Colston Budd Rogers & Kafes Pty Ltd

**RE: STAGE 3 (DFO) EASTERN CREEK QUARTER
PROPOSED CHURCH STREET TRAFFIC SIGNALS**

**RE: STAGE 3 (DFO) EASTERN CREEK QUARTER
RESPONSE TO MATTERS RAISED BY TFNSW**

Title
**INTERSECTION LAYOUT - WORKS PLAN
SHEET 2 OF 2**

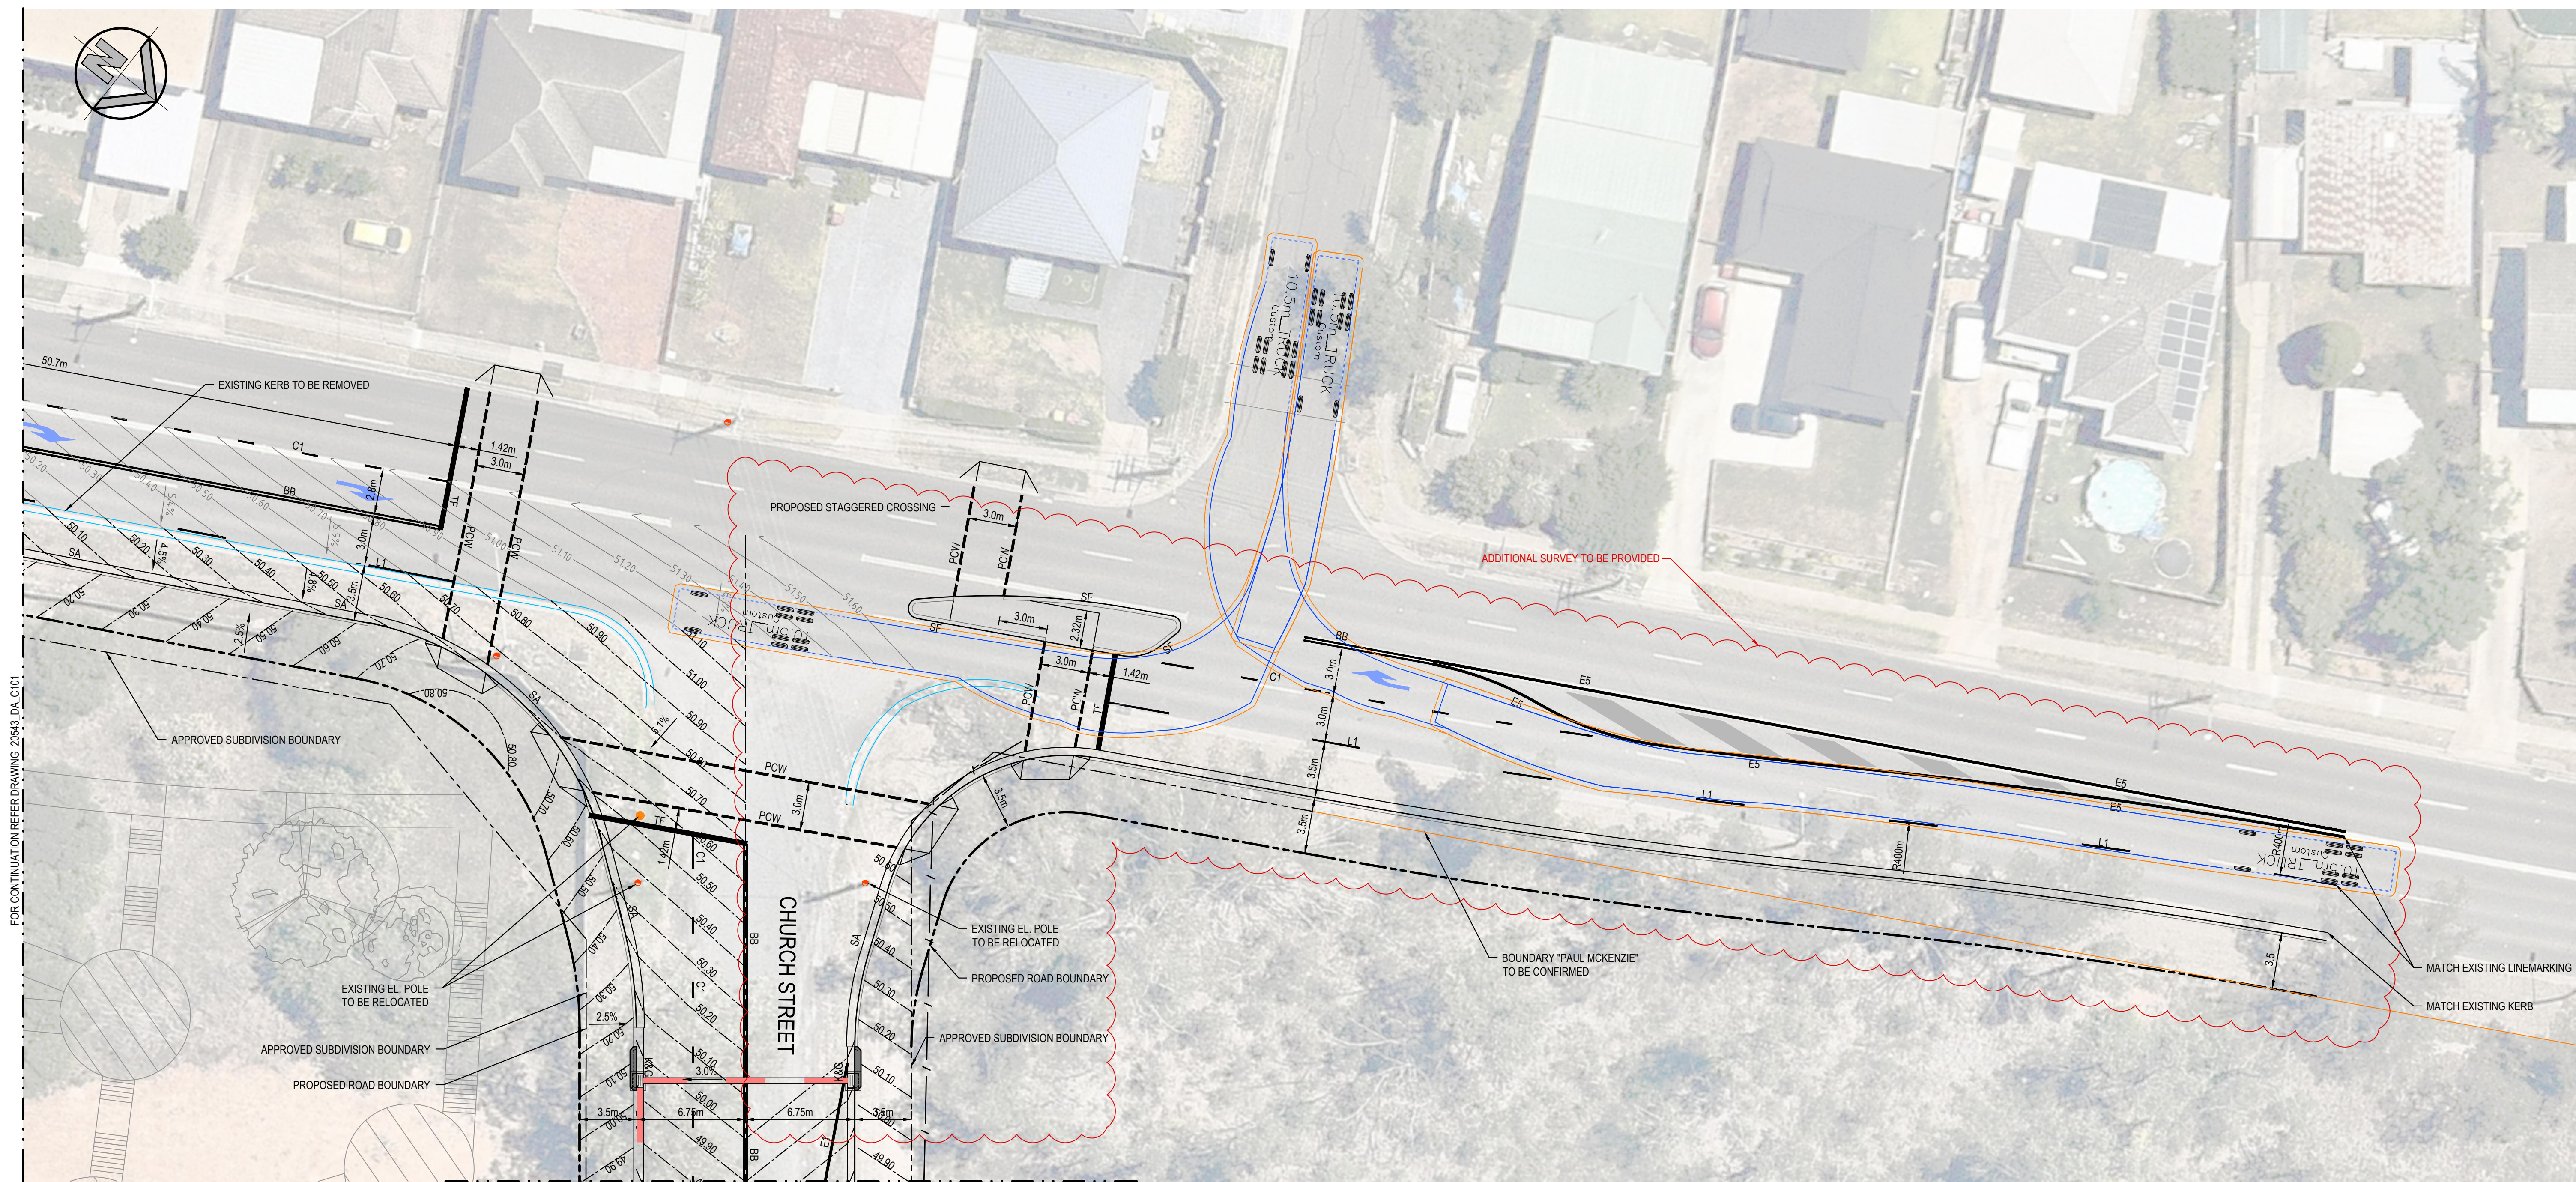
1. As requested we have reviewed the matters raised by TfNSW at a meeting on 25 May 2021 with regards to the proposed traffic signals at the intersection of Rooty Hill Road South and Church Street. The matters raised are summarised below:

- the impact the traffic signals would have on access to St Agnes Avenue and Minchinbury Street; and
 - southbound sight lines on Rooty Hill Road South to the proposed traffic signals at Church Street.

3. The draft plans of the proposed traffic signals showed:
 - a median on Church Street restricting access to St Agnes Avenue (which is a no through road) to left in/left out; and

- a break in the painted median opposite Minchinbury Street (this would allow for all turning movements).
4. Both St Agnes Avenue and Minchinbury Street are local roads providing access to residential development. A count of turning movements in the weekday afternoon peak period at the intersections of Rooty Hill Road South with St Agnes Avenue and Minchinbury Street were undertaken on Monday 31 May 2021. These found low volumes of traffic turning right to/from St Agnes Avenue and Minchinbury Street as set out below:

7. A review of southbound approach on Rooty Hill Road South to Church Street found there are some 140 metres of sight lines for southbound traffic once traffic passes the crest and bend located between Evans Road and Church Street. AUSTROAD Guidelines suggest a minimum Stopping Sight Distance (SSD) for traffic signals in a 60 km/h speed environment of 73 metres for cars and 81 metres for trucks. The provision of 140 metres satisfies this requirement and would satisfy the SSD for an 80 km/h speed environment (114 metres for cars and 131 metres for trucks).

5. As noted above the proposed traffic signals would not limit right turns to/from Minchinbury Street. With regards to St Agnes Avenue, the attached concept plan of the proposed traffic signals provides a break in the median with a separate 20 metre right turn so as to allow right turns from Rooty Hill Road South. This short right turn bay would accommodate the low number of vehicles turning right into St Agnes Avenue (some 5 vehicles per hour). TfNSW advised that, with traffic signals at Church Street, it would not permit right turns out of St Agnes, due to the proximity to the signals.

9. As noted above, the proposed traffic signals at Church Street would not restrict access at Minchinbury Street and the plan has been modified to allow right turns into St Agnes Avenue. TfNSW has advised that it would not support the right turn out of St Agnes Avenue. The banning of the right turn out would have minimal impact as set out below:
- the small number of vehicles that currently turn right would be diverted to turn left onto Rooty Hill Road South and use the alternative route to travel south as described in paragraph 6;
 - no impact on public transport services; and
 - emergency vehicle access to/from St Agnes Avenue would be maintained (through the provision of the break in the median).
10. We trust the above provides the information you require. Finally, if you should have any queries, please do not hesitate to contact us.

ROAD LAYOUT - WORKS PLAN

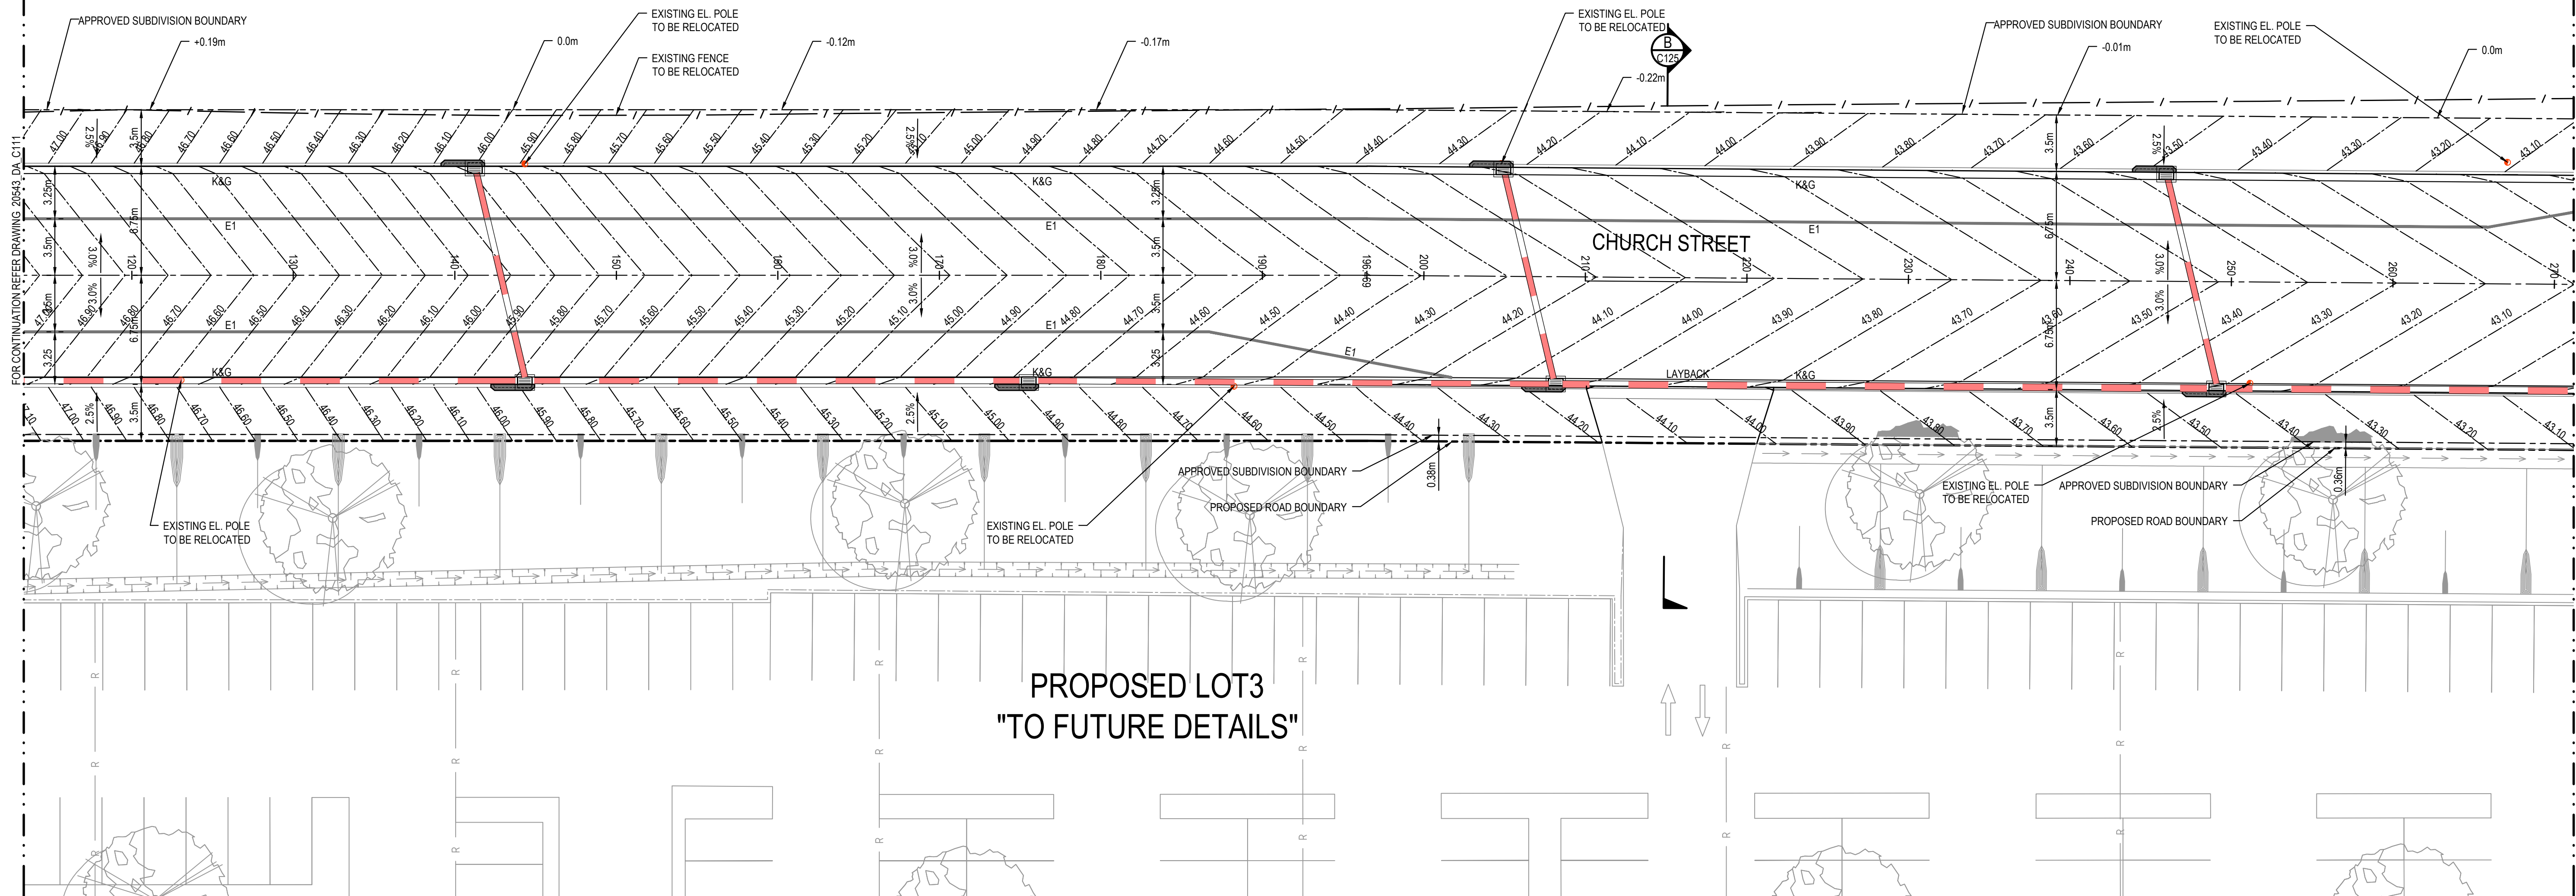
The first vehicular access on Church Street closest to the intersection with Rooty Hill Road South is not supported due to potential queuing impacts on Rooty Hill Road South. All vehicular access should be provided at the northern boundary of the site.

15. We understand that the reason for TfNSW not supporting the current location for access to the at-grade car park is a concern that queuing may extend back from the intersection with Church Street and block access to the site. To address this concern the at-grade car park access has been relocated further to the east some 170 metres from Church Street. This is well clear of the

potential queuing from Church Street, The updated SIDRA analysis found a 95% back of queue on Church Street of 50 metres and 65 metres in the weekday afternoon and Saturday midday peak hours respectively.
